City of Portland, Maine - Building or Use Permit Application
 389 Congress Street, 04101 Tel: (207) 874-8703, Fax: (207) 874-8716

Permit No: 09-1221	Issue Date:	CBL: 087 00007001
------------------------------	--------------------	-----------------------------

Past Use: Single Family Home	Proposed Use: Single Family Home - Enclose existing Porch	Permit Fee: \$200.00	Cost of Work: \$18,000.00	CEO District: 1
Proposed Project Description: Enclose existing Porch		FIRE DEPT: <input type="checkbox"/> Approved <input type="checkbox"/> Denied	INSPECTION: Use Group: Type	
		Signature:	Signature:	
PEDESTRIAN ACTIVITIES DISTRICT (P.A.D.)				
Action <input type="checkbox"/> Approved <input type="checkbox"/> Approved w/Condition <input type="checkbox"/> Denied				
Signature: Date:

ZIMMERMAN RESIDENCE
PORCH ENCLOSURE
9-22-08

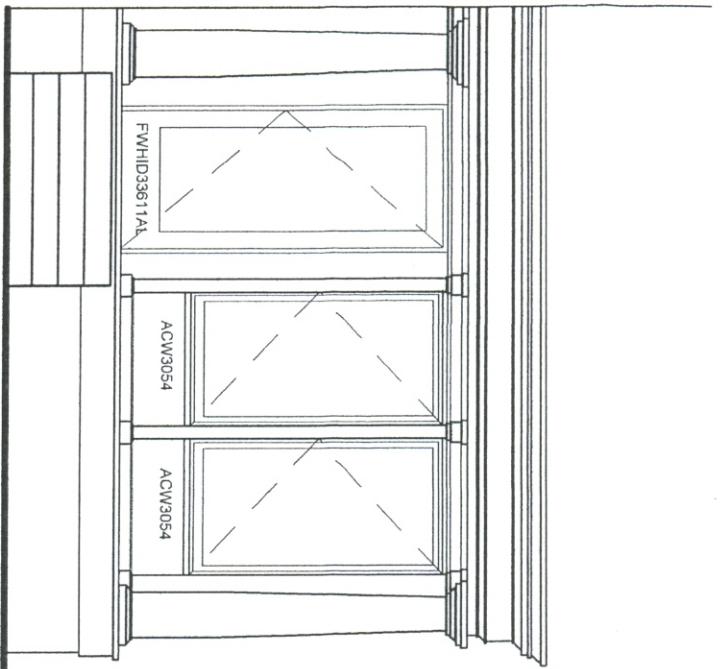
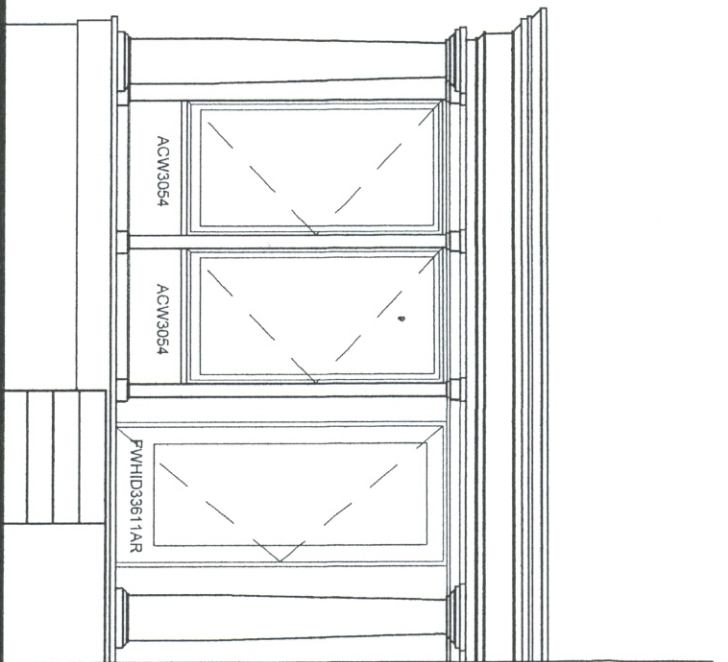
Comments:
11/9/2009-tm: called contractor Bill Bunton and requested info on window framing including headers.
